Subject: SUBMISSION Epping to Thornleigh Third Track Environmental Impact Statement

I hereby register my objection to the inadequacies in the EIS prepared for the proposed Epping to Thornleigh Third Track on the following grounds and with the following areas requiring urgent & complete addressing:

Figure S.6 Cross-section and elevation - New Cheltenham Station concourse building (see also S.5 for artist's impression)

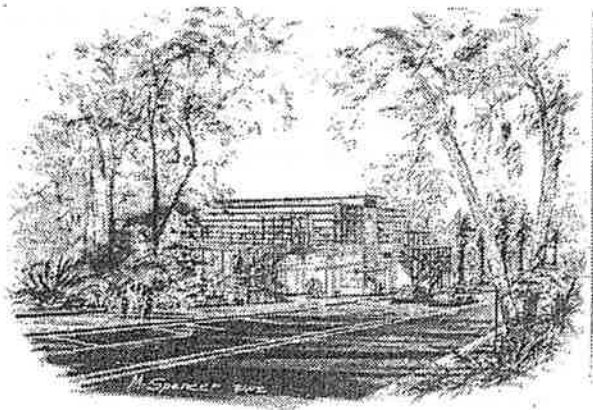
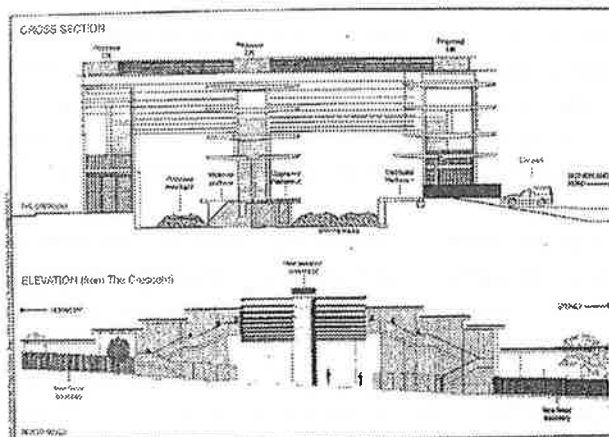
The placement of the third line on the western side of the **Cheltenham Station** platform will require a free standing overhead bridge with lifts to the platforms. This is unacceptable because of;

- The visual impact of the proposed overhead bridge with lifts to the platforms.
- The need for stairs and or ramps in case of lift breakdown and to meet statutory disability requirements
- The lengthening of the car park on the western side to Lyne Road goes through an area subject to flooding and a registered Aboriginal Archaeology site
- There is no plan to upgrade Beecroft Station.
- The loss of trees of high heritage value, Blue Gum High Forest and wild life corridors which will impact on the last remaining Gang Gang Cockatoo population in Sydney
